FALCON MEADOWS AT BENT GRASS FILING 4

LETTER OF INTENT

JUNE 2022

N.E.S. Inc. on behalf of Challenger Homes request approval of the Falcon Meadows at Bent Grass Filing 4 Plat for 39 single-family residential lots, and 7 tracts on 10.42 acres.

FALCON MEADOWS AT BENT GRASS FILING NO. 4

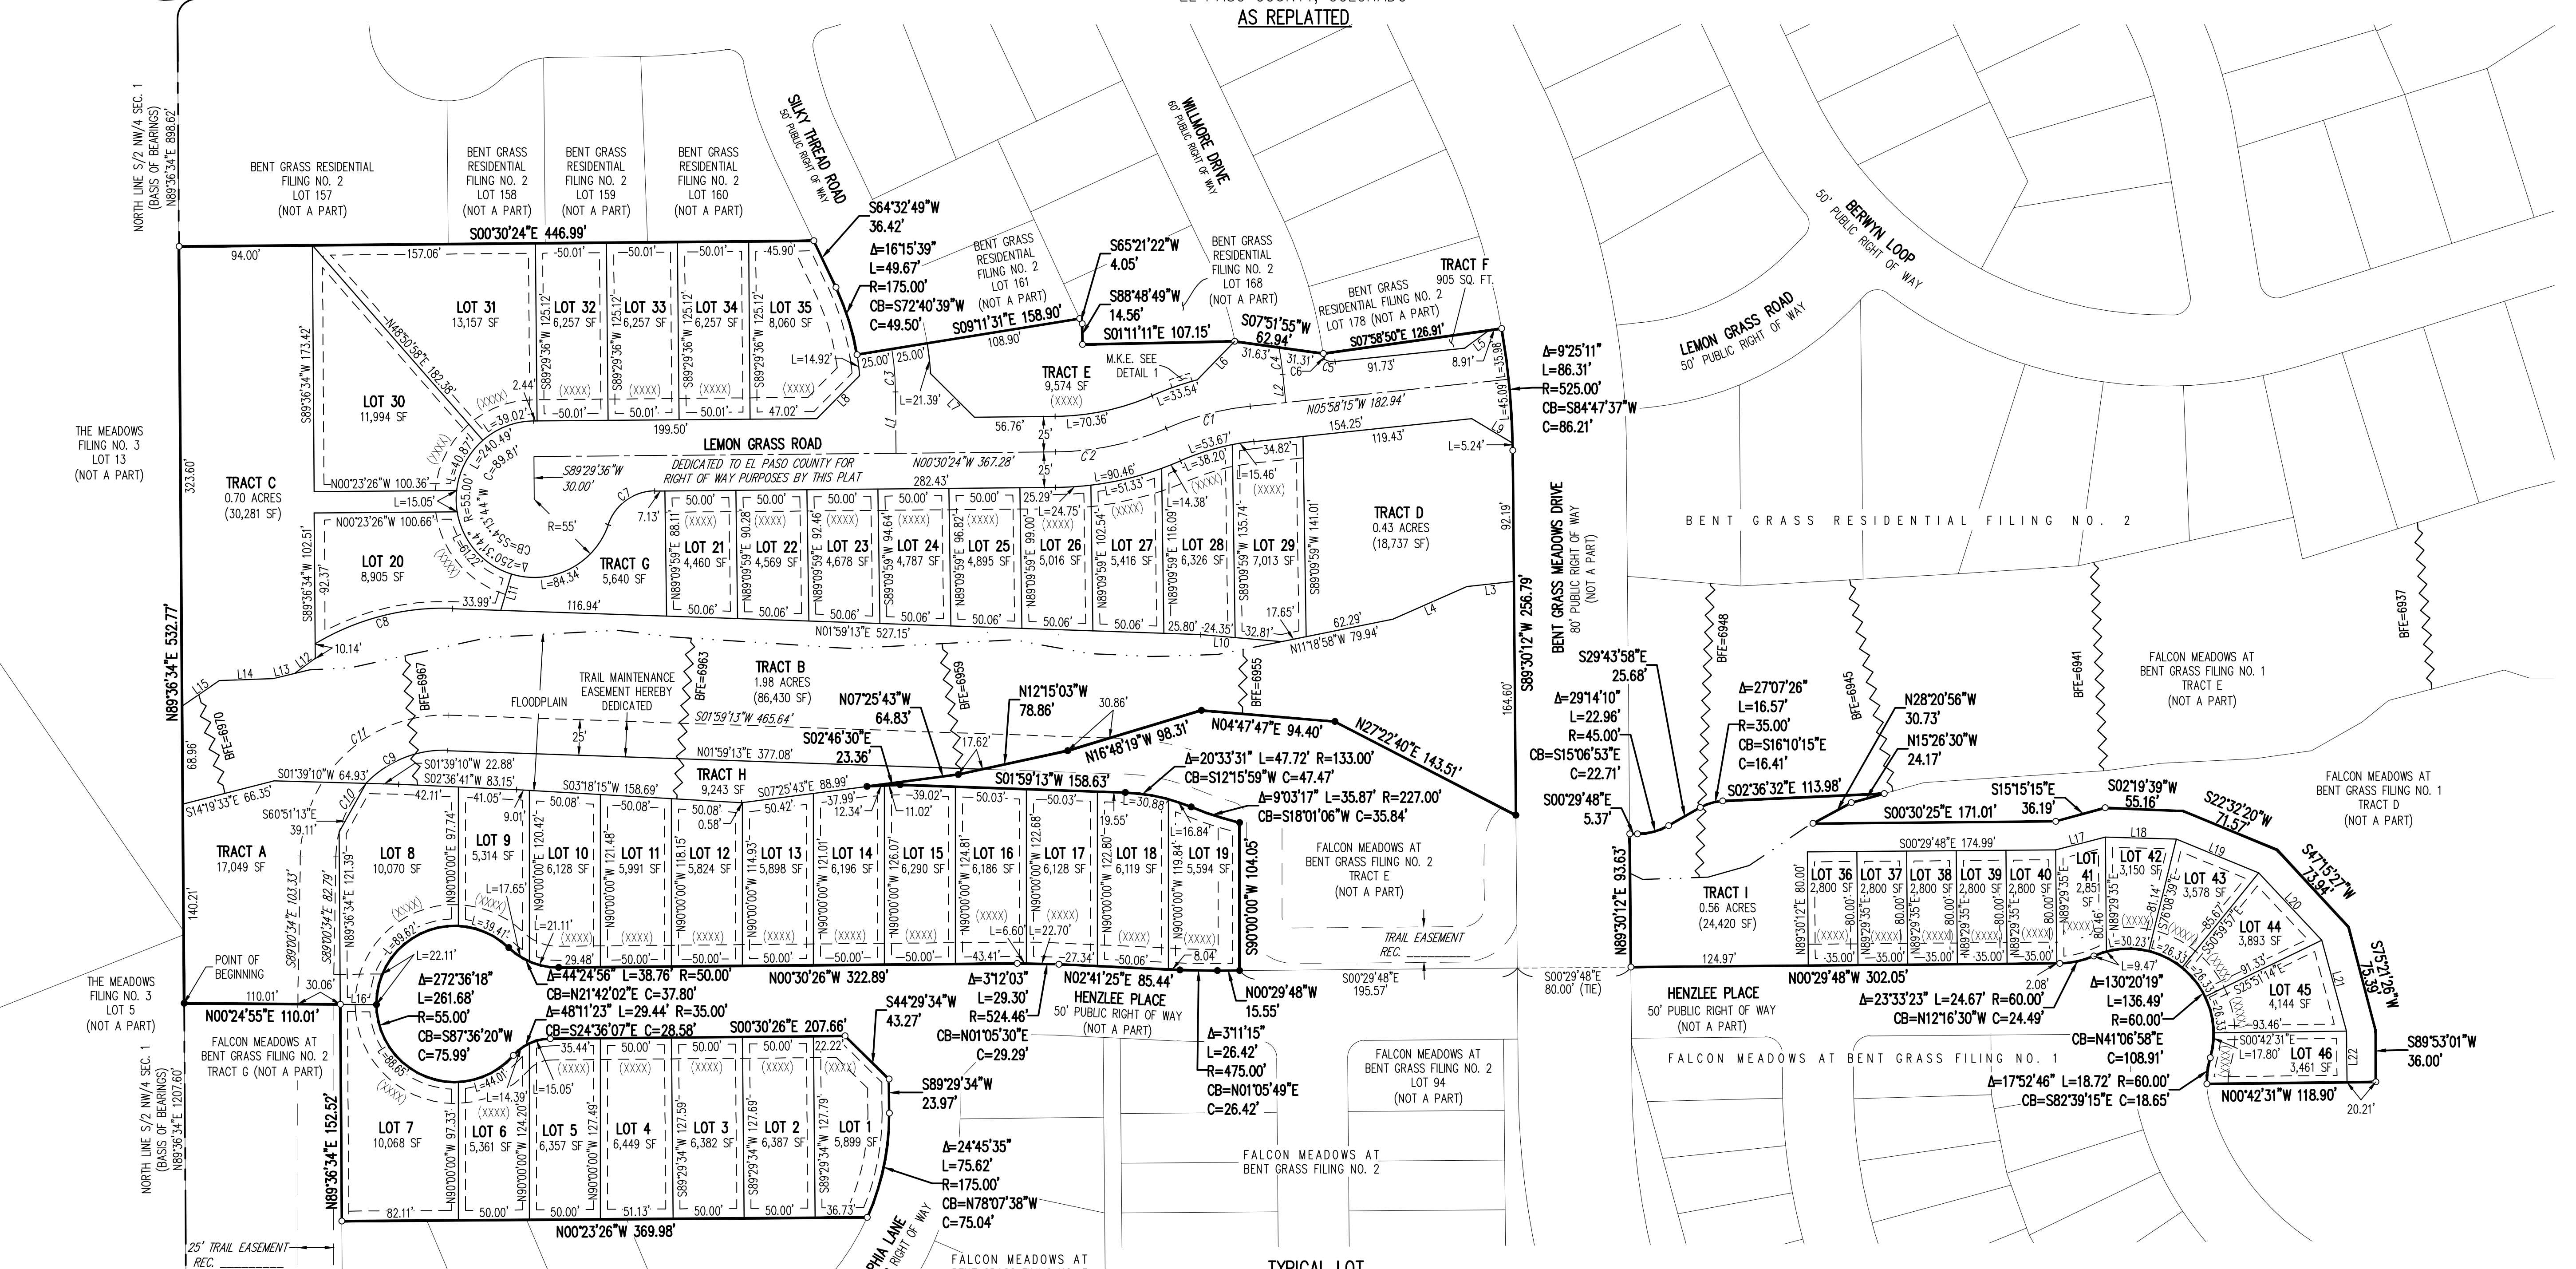
identify required wall to be constructed by developer at northern end as mitigation to rural lots to the north please.
